**Consultation Response from KC, Conservation & Design****2024/91501 16, Nabbs Lane, Slaithwaite, Huddersfield, HD7 5AU****Erection of front porch (within a Conservation Area)****Date Responded: 16.7.2024****Responding Officer: Sue Brooks****Responding Ref:**

Drawing Title  
**EXISTING AND PROPOSED PLAN AND FRONT ELEVATION**

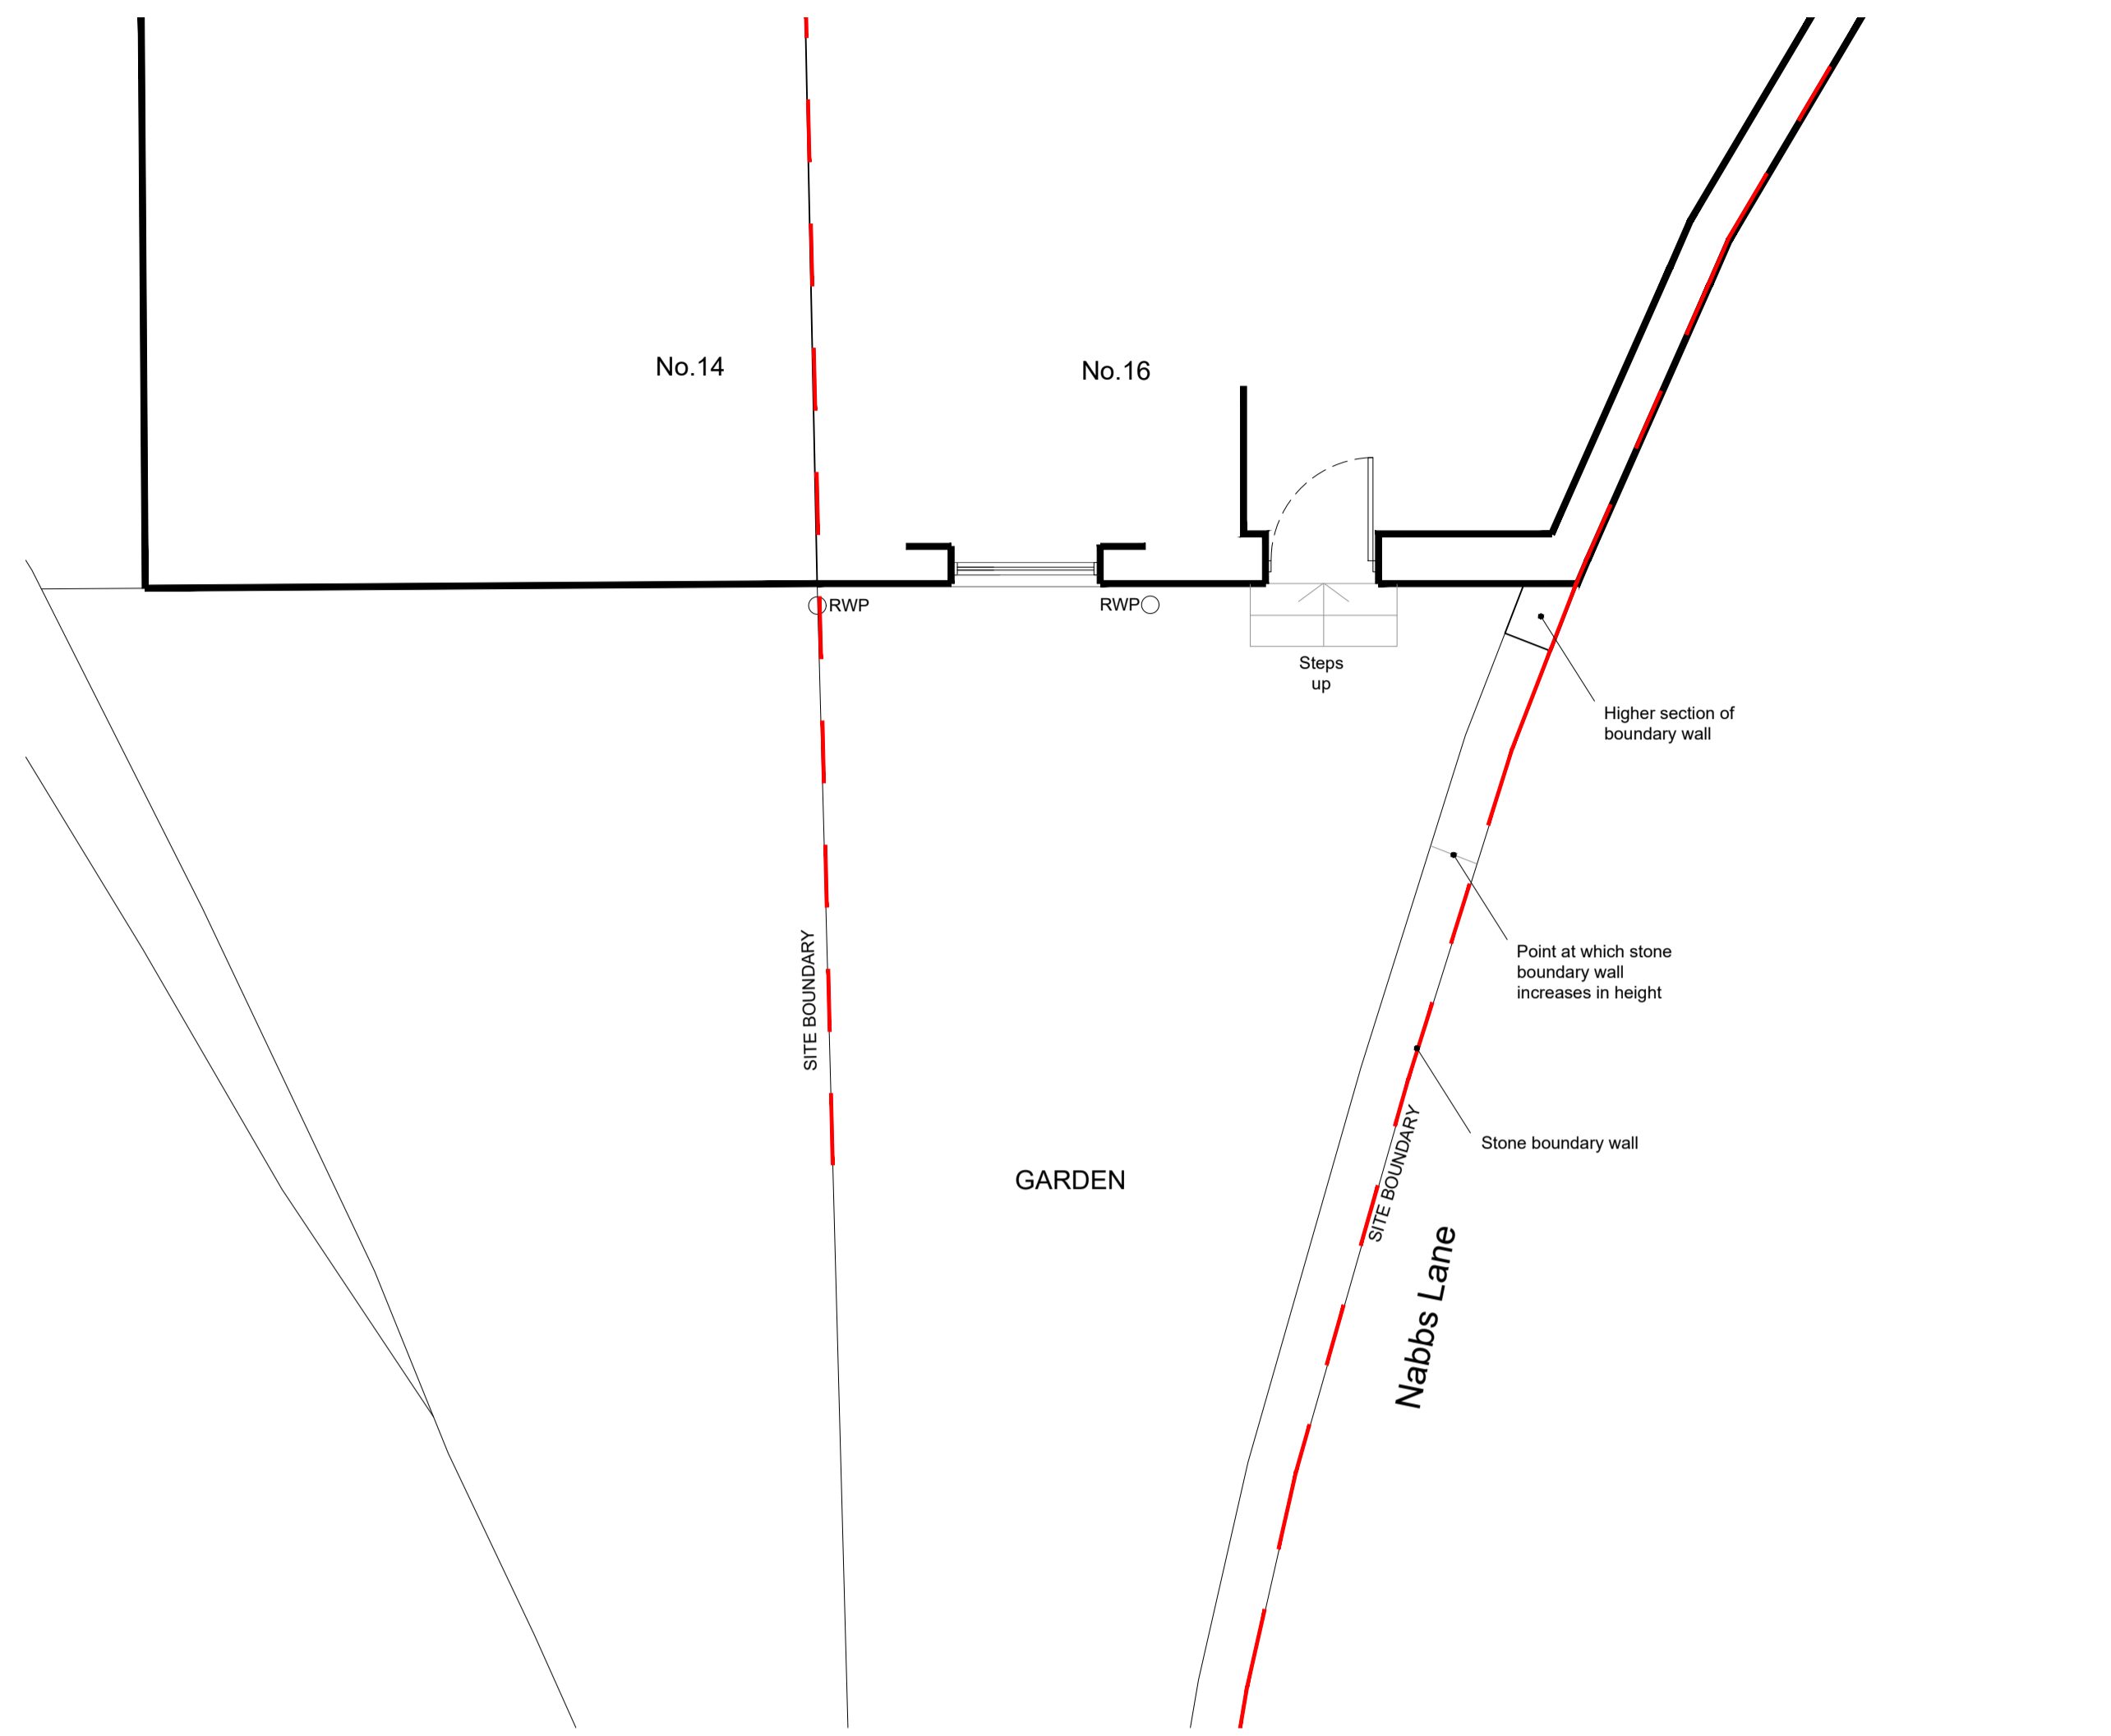
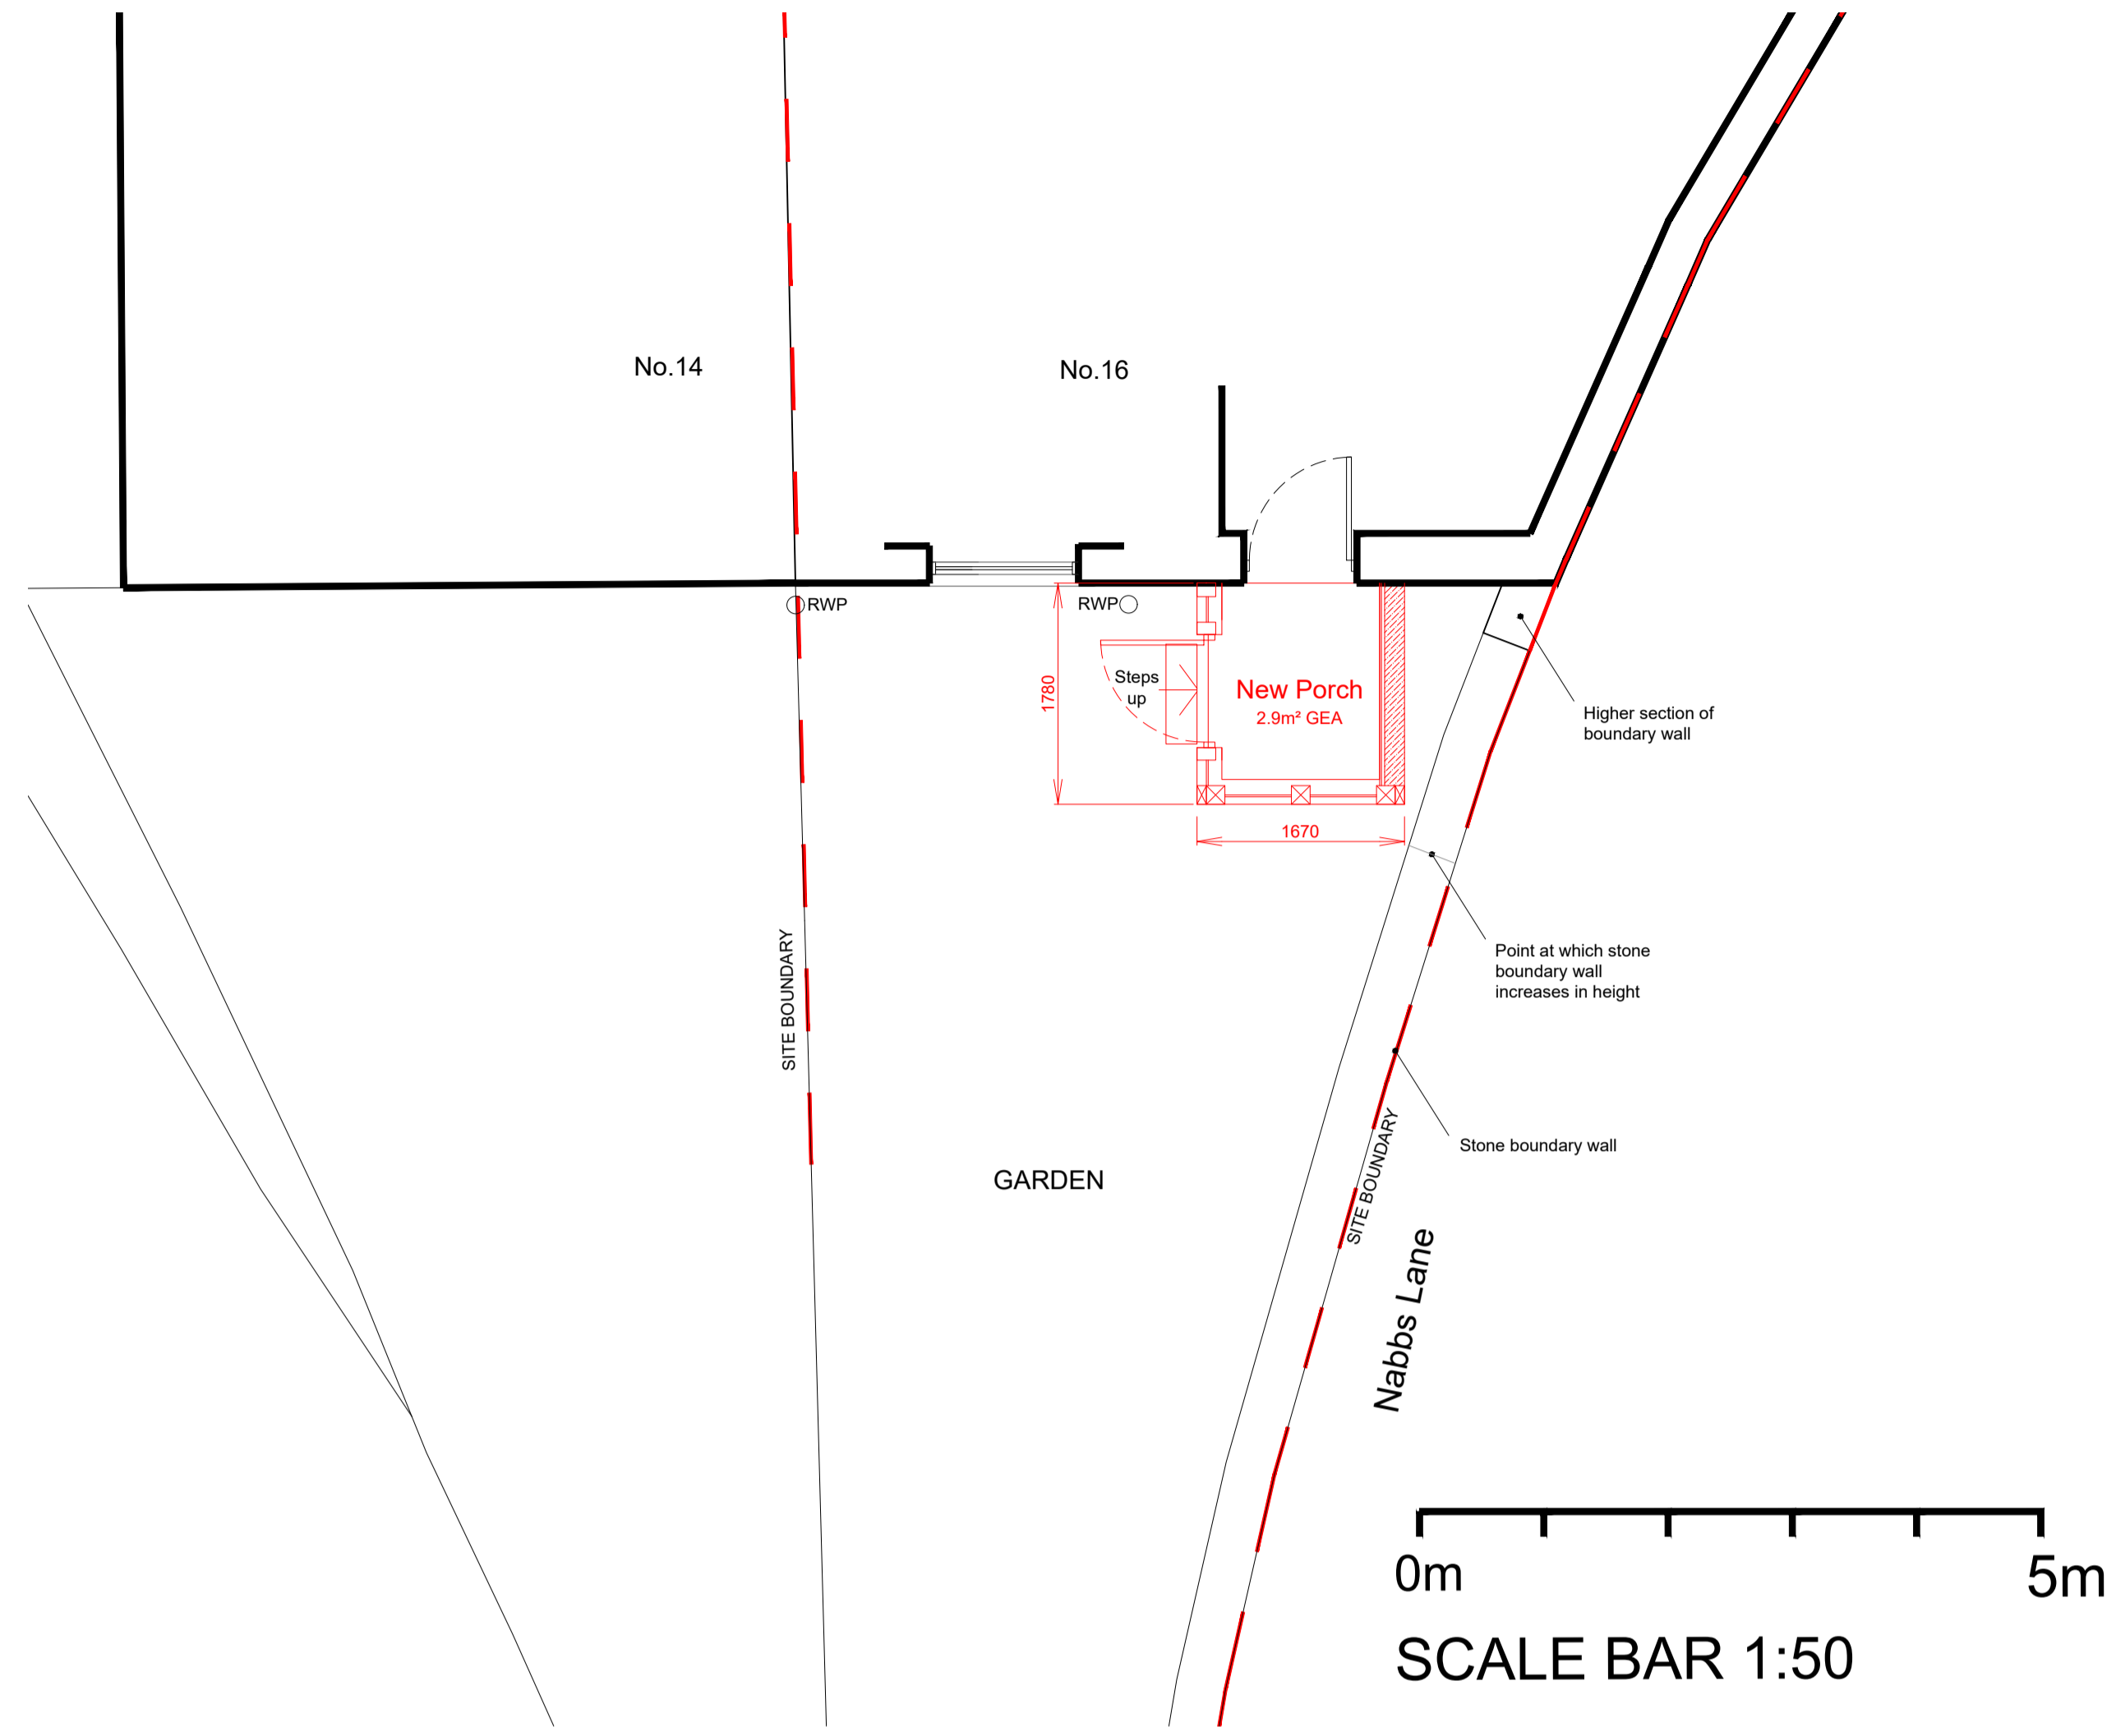
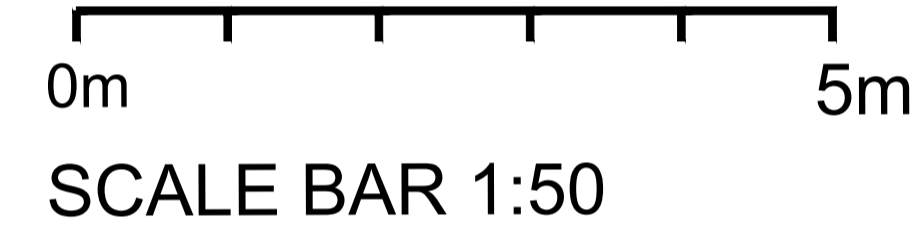
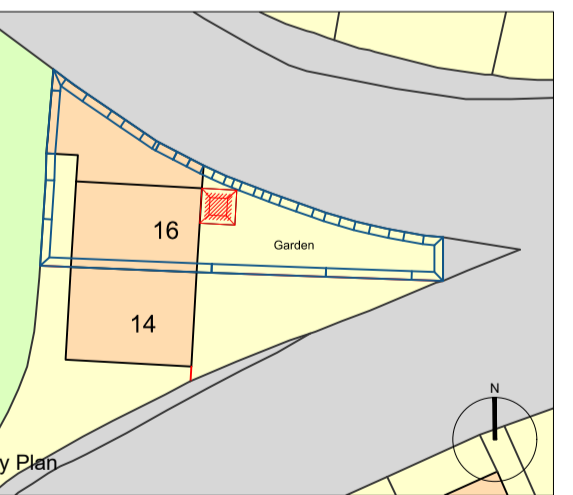
This retrospective application is for a glazed oak framed front porch with a dual-pitched blue slate roof, with a coursed stone north elevation and dwarf wall. This substantial porch structure obscures the doorway up to the height of the moulding and disrupts the symmetry of the elevation by introducing a large dual-pitched structure on this otherwise low-key elevation. It is highly visible when viewed from the east from both Nabbs Lane and Howgate Road, due to its position to the right of the façade, the elevated position and the low boundary wall of the front garden. The materials – a heavy oak frame and expanse of glazing, are out of character with the local vernacular which is typified by natural stone.

The Conservation and Design Team has concerns about the development on heritage and design grounds particularly with regards to our statutory duties under sections 66(1) and 72(1) of the Planning (Listed Buildings and Conservation Areas) Act 1990, policies LP24 and LP35 of the Local Plan and paragraphs 205, 206, 208 and 212 of the NPPF (20 December 2023). The porch extension does not preserve or enhance the character or appearance of the conservation area or preserve the setting of the Grade II listed viaduct directly behind the dwellings. The form, scale, materials and details of the porch do not respect or enhance the character of the townscape or designated heritage assets – the conservation area and viaduct. The proposed development would cause less than substantial harm to their significance, no justification has been provided for that harm and no public benefits have been demonstrated. We are unable to support this application.
